**SUBJECT: Ellicott Town Center – Filing No. 1
Response to County Review Comments
SF-18-025**

In conjunction with our Filing No. 1 final plat re-submittal, this letter provides responses to the County review comments discussed in the letter from PCD-Planning dated October 9, 2018 and the Memorandum from PCD-Engineering dated October 5, 2018. These comments are specifically addressed as follows **(Applicant responses are annotated in bold / red / parenthesis following each County comment):**

G2

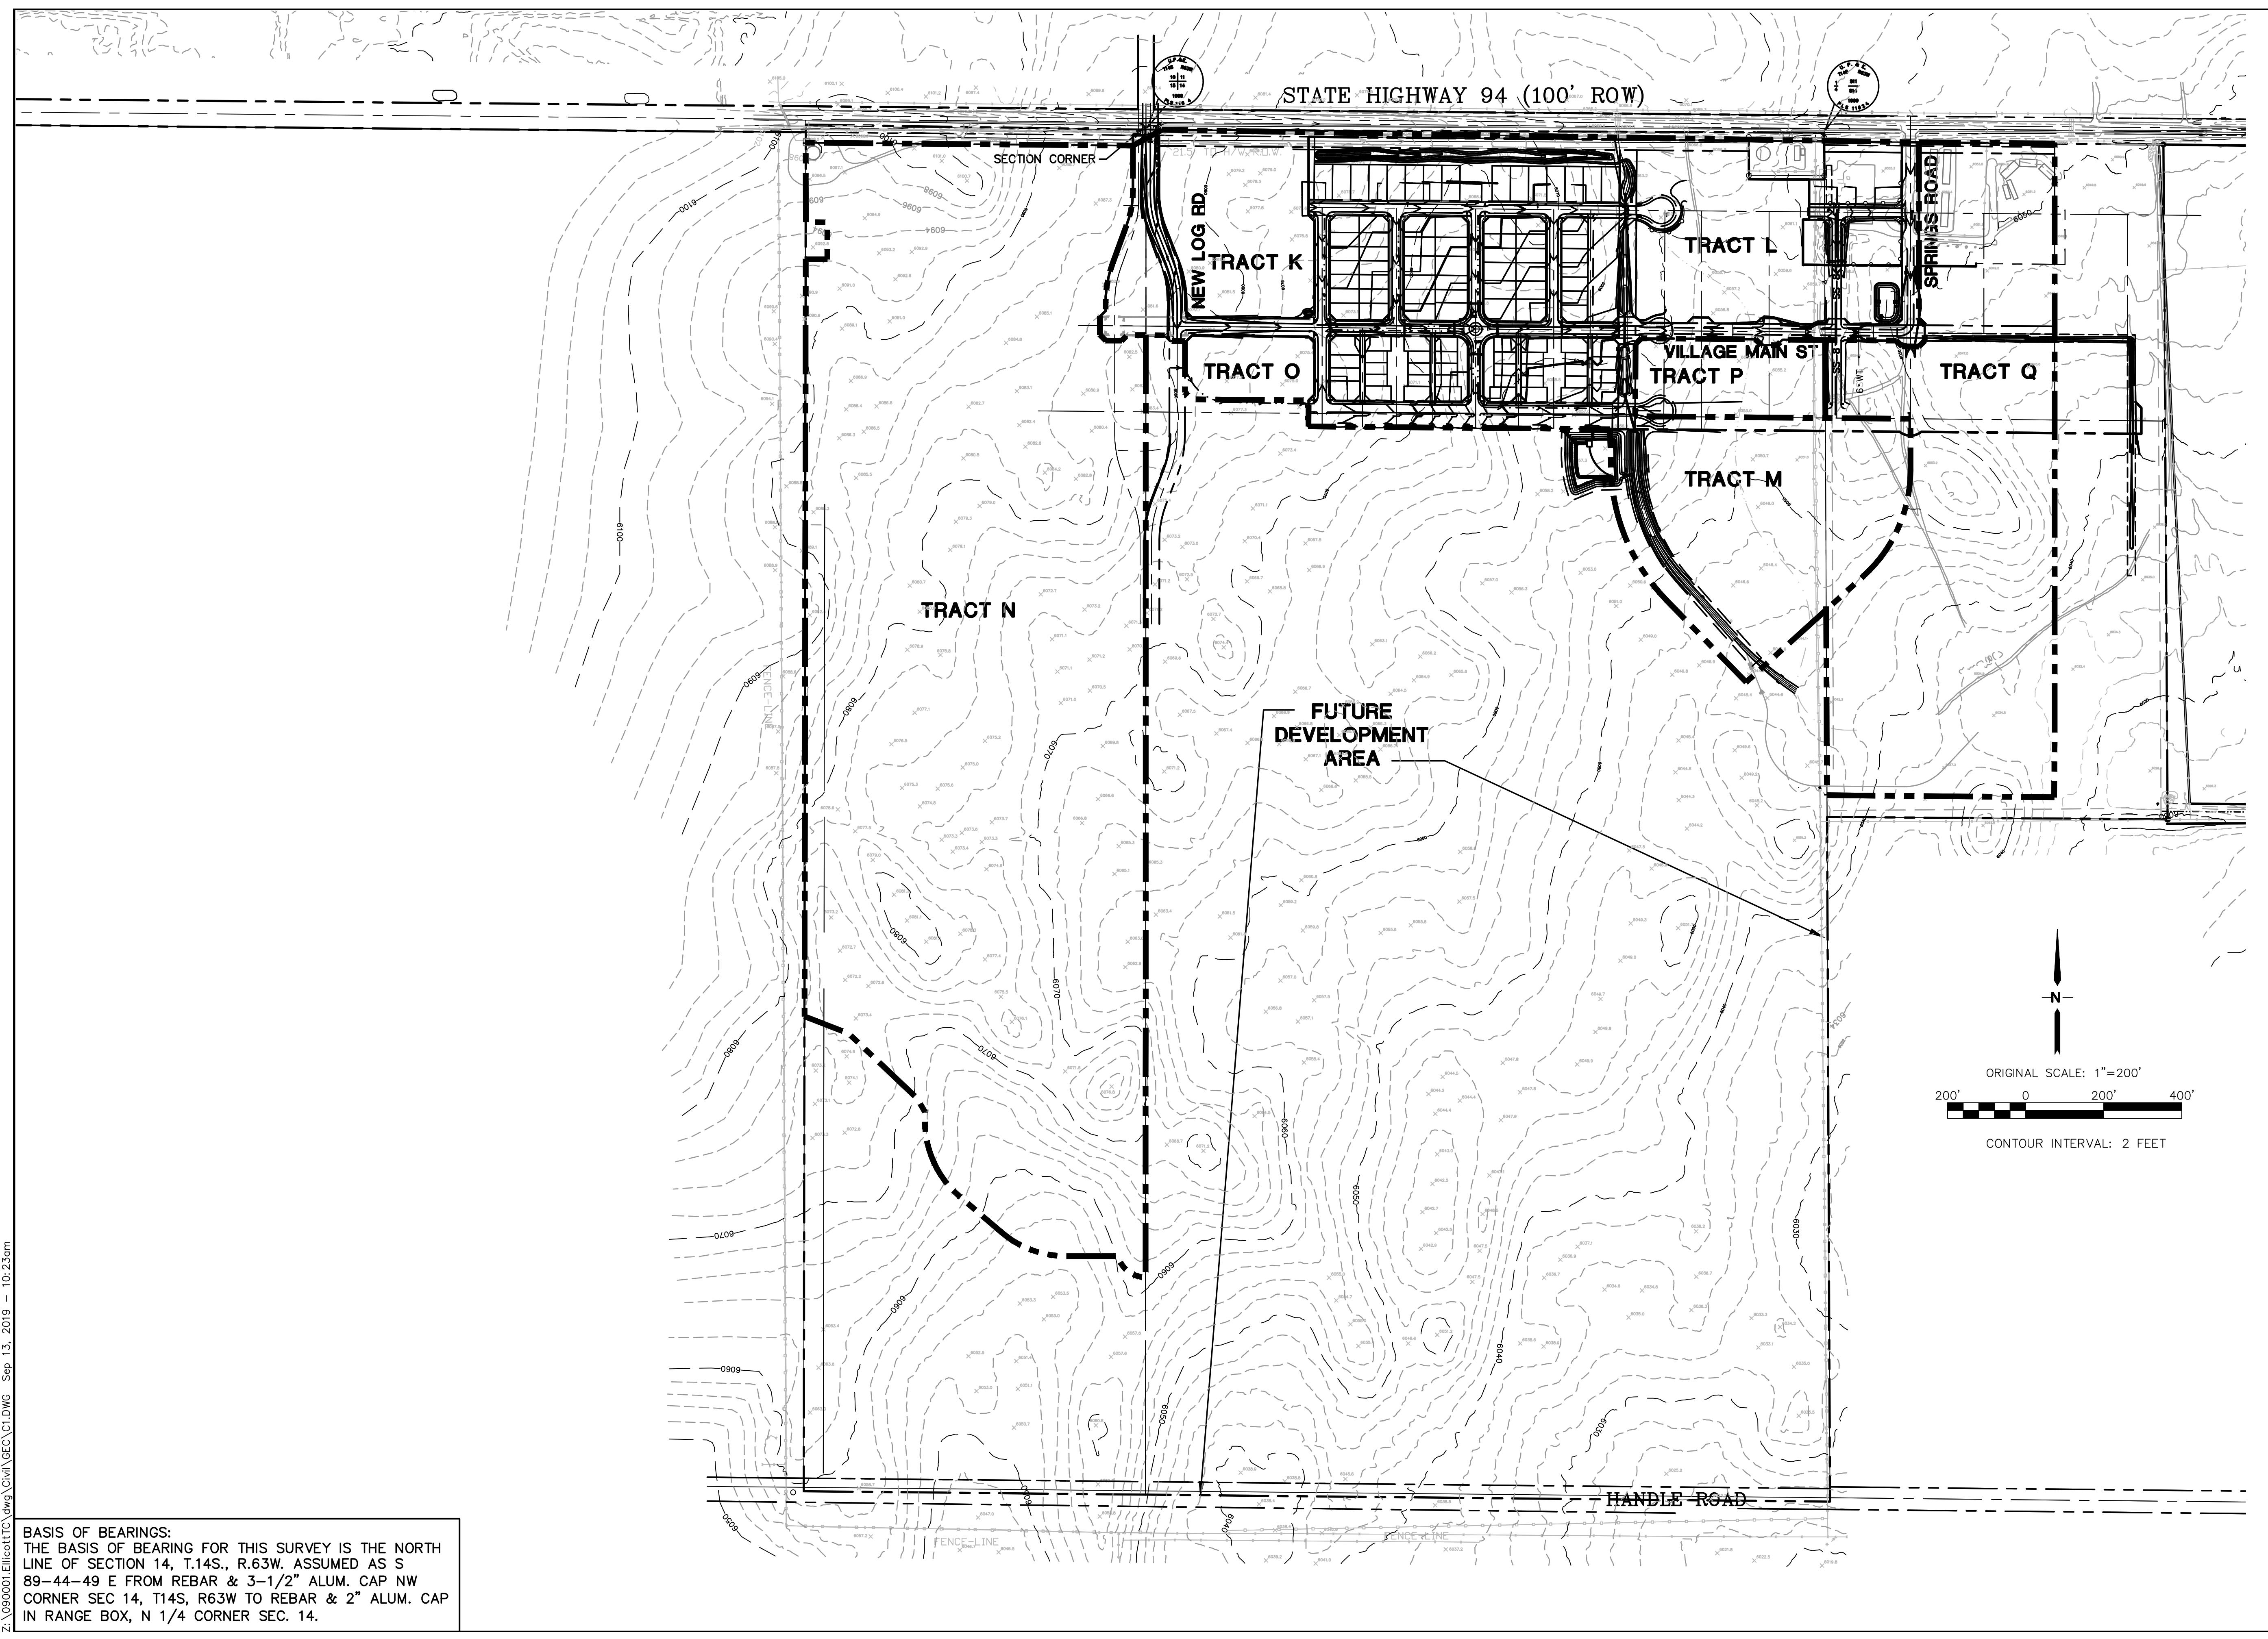
5. Provide the 100-yr HGL calculations and show on the CDs. **(Provided calculations in Appendix D1, and HGL shown on applicable storm sewer plan and profile drawings)** Specify watertight joints if the storm drain system will be in pressure flow conditions/surcharge. **(Included in General Note #4 on Sh. G2)**

SHEET:
C1.02

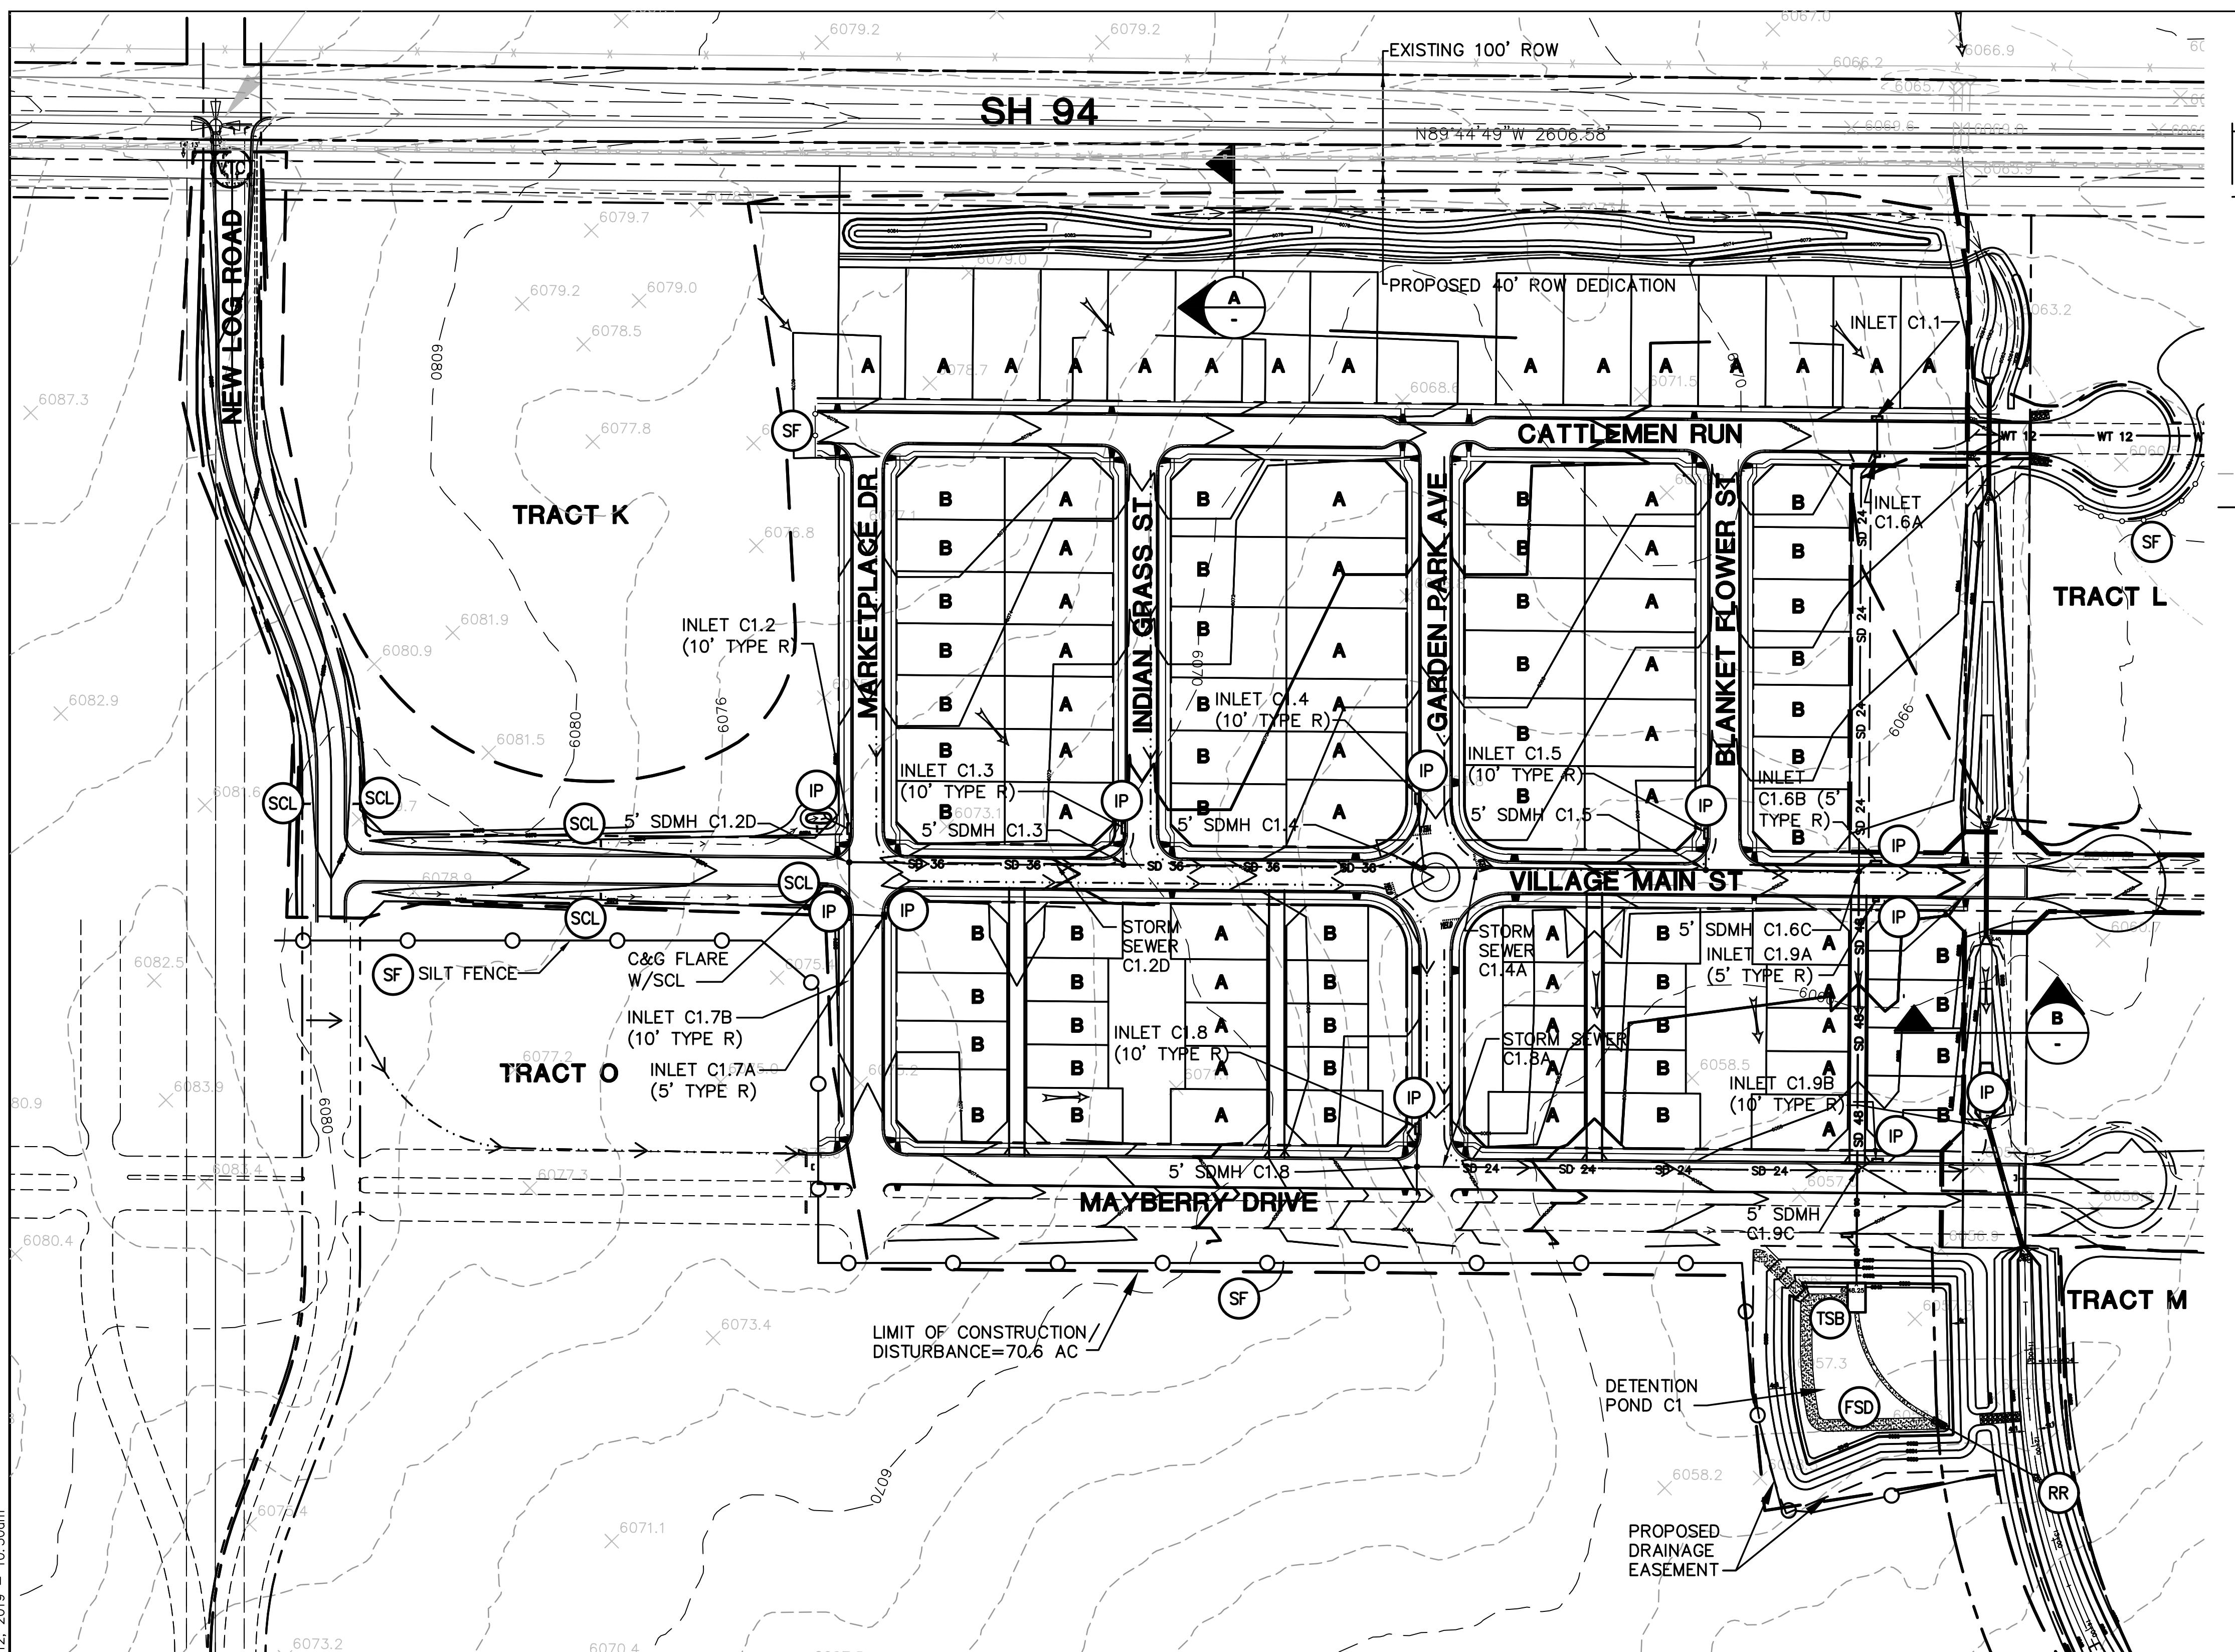
5. Provide complete mini-roundabout design for the Garden Park/Village Main intersection. **(Clarified details on Sh. TS1)**
6. Ensure that stabilization/sediment control is provided for all transitions from undeveloped areas to developed areas and vice versa, and that enough detail is provided for construction. **(Clarified on Sh. C1.02 and PP6)**
